Application No: Y/62/22/HH  
Site Address: 27 Goodhew Close Yapton BN18 0JA  
Description of works: Erection of detached single storey annexe in rear garden.

OWPC48293

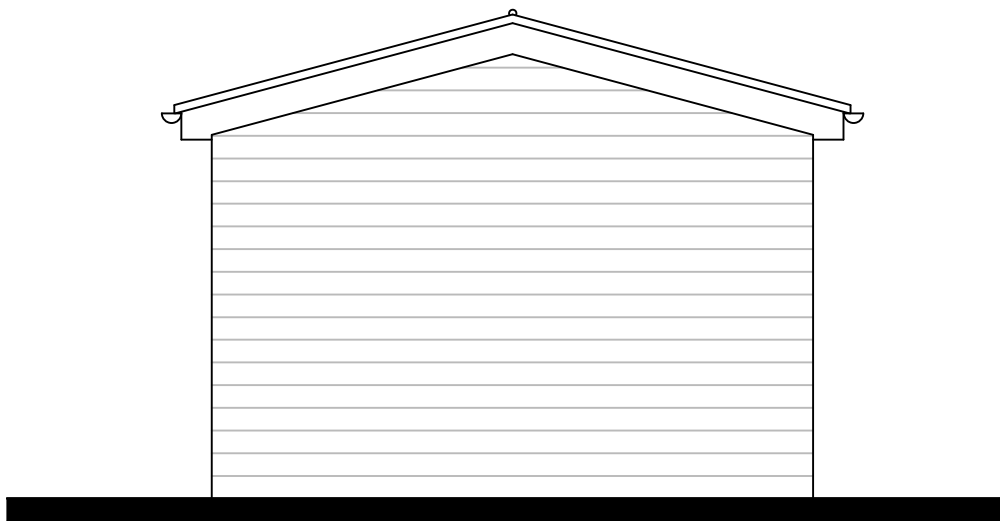
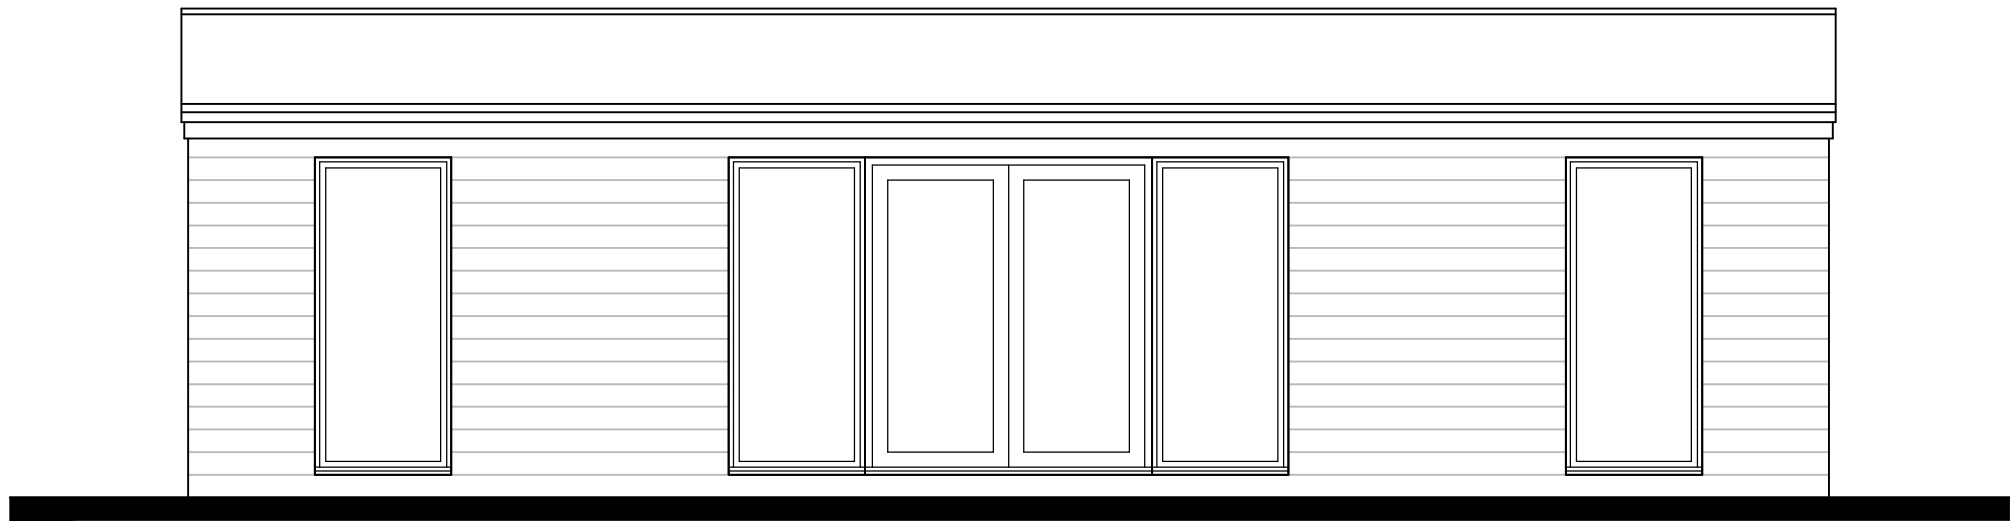
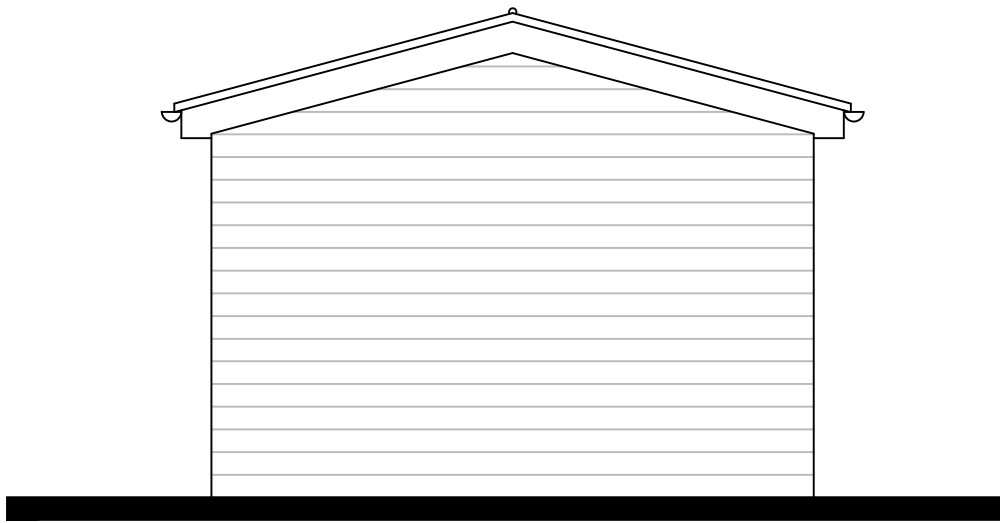
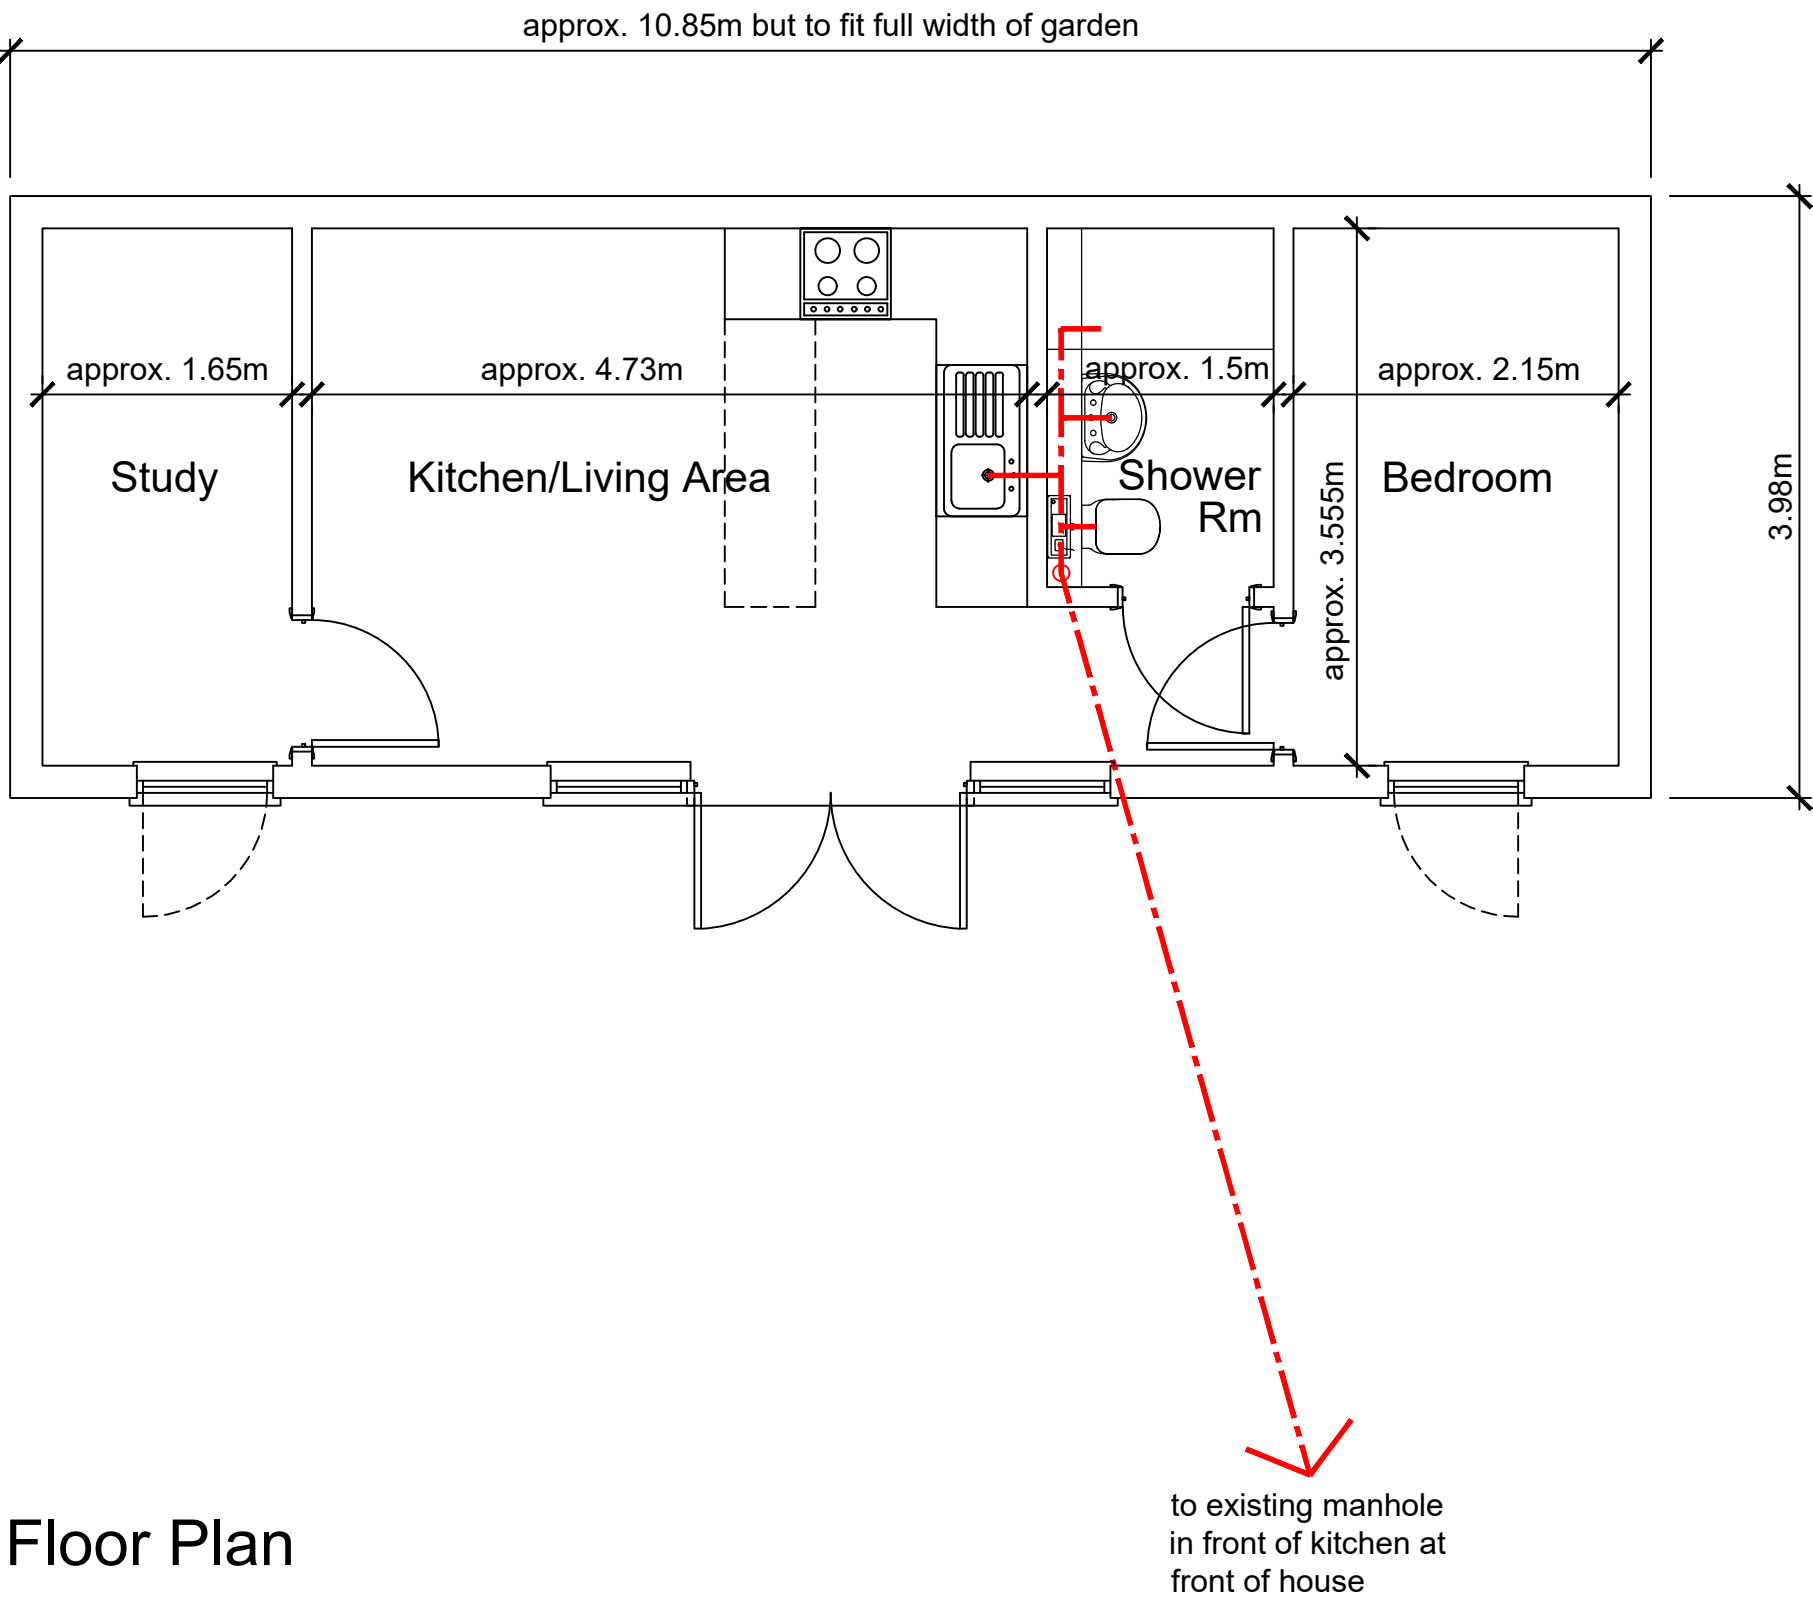
27 Goodhew Close is a detached residence in a modern housing development. The garden is not huge and the proposed annex is not simply an extension, but an additional dwelling with its own kitchen and shower room. This seems unlikely to be simply ancillary to main the residence and represents a significant over development of the plot. The plans as submitted lack any detail on either the purpose of this new dwelling or construction method and materials, leading us to assume the worst in terms of the impact it will have on Emerald Gardens.

The location of the new dwelling brings the occupied building on Goodhew Close closer to Emerald Gardens. This increases the possibility of ongoing or future noise, nuisance, and disturbance to the residents of Emerald Gardens from this new dwelling. The application is short on details of the dwelling cladding, but on the elevation plans it looks like it will be wood cladded, if this is the case then regular and ongoing access will be required through Emerald Gardens land to maintain the dwelling which will itself be a nuisance. Wood

cladding is also unlikely to provide sufficient soundproofing for a new residential dwelling with any significant level of occupation - it will become a noise nuisance to residents of Emerald Gardens.

There are no details of rainwater management and guttering on the plans for this dwelling. Emerald Gardens would like assurance that any rainwater collected on the annex roof will be captured and diverted away from Emerald Gardens land, rather than draining onto Emerald Gardens land.

Proposed Block Plan

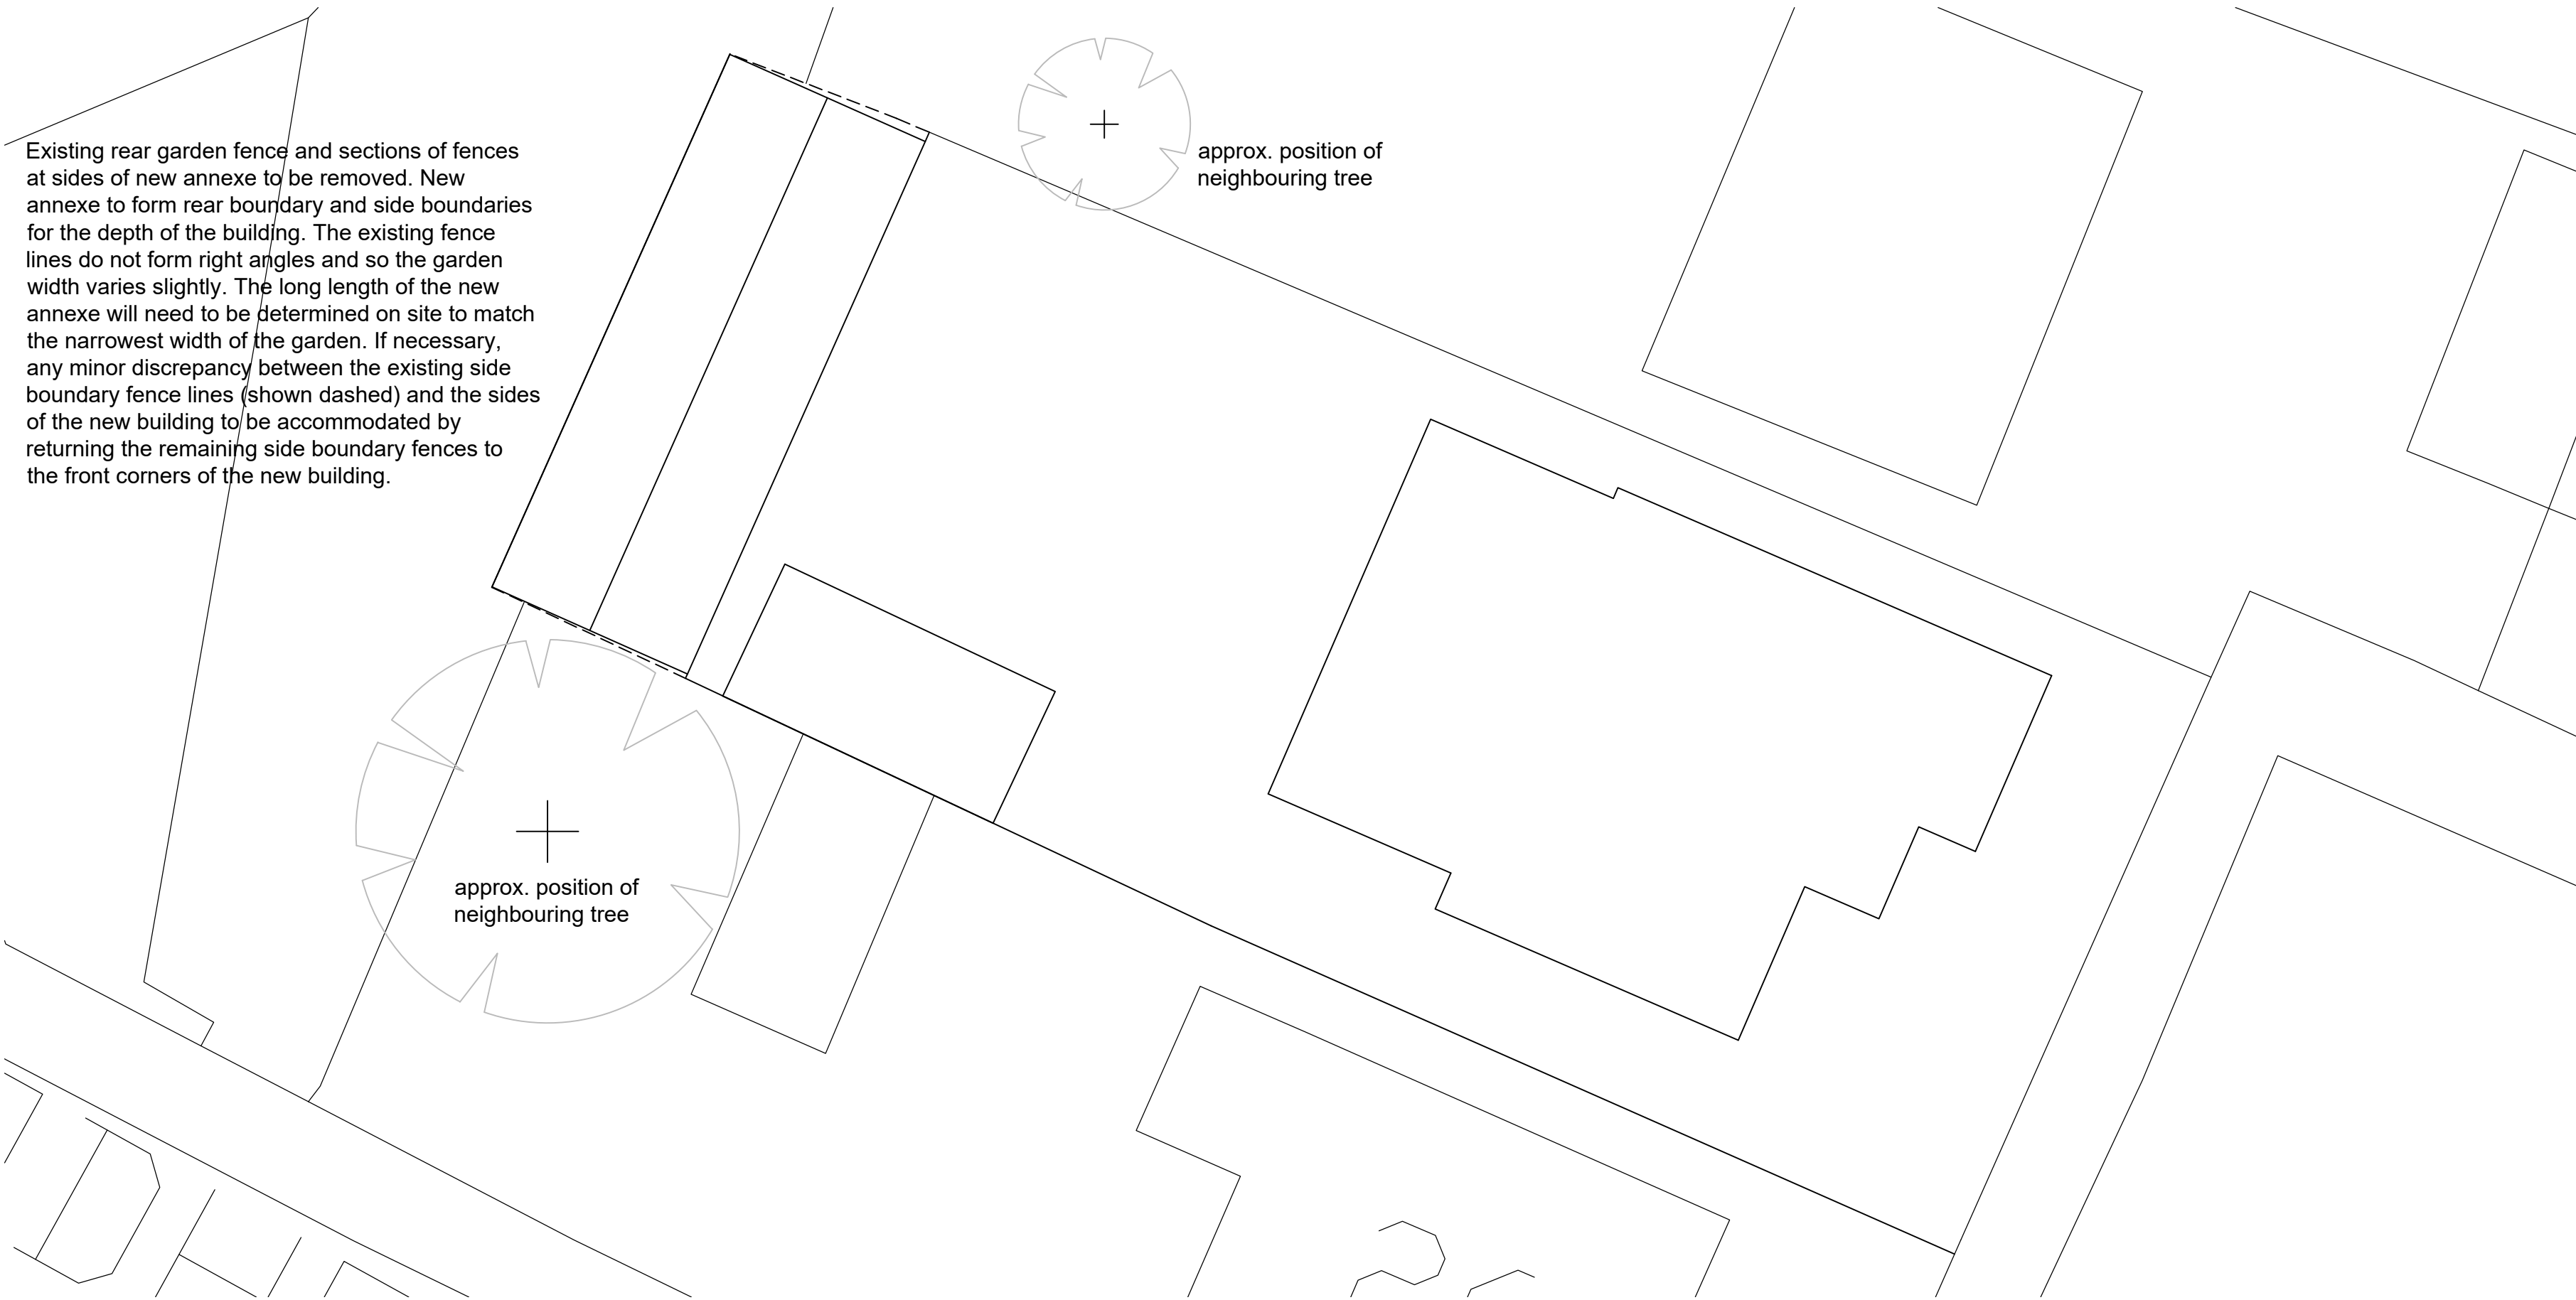
While it would not address the concerns around over-development, noise, and parking (and therefore the objection would remain), Emerald Gardens would be more comfortable with this development if it were set fully within the 27 Goodhew Close plot and not on the boundary. Placing this dwelling within the plot with space around for maintenance access means that ongoing access to Emerald Gardens land is not required for regular maintenance. Alternatively, assurances that the materials used will require no ongoing maintenance for the lifetime of the dwelling will be welcomed.
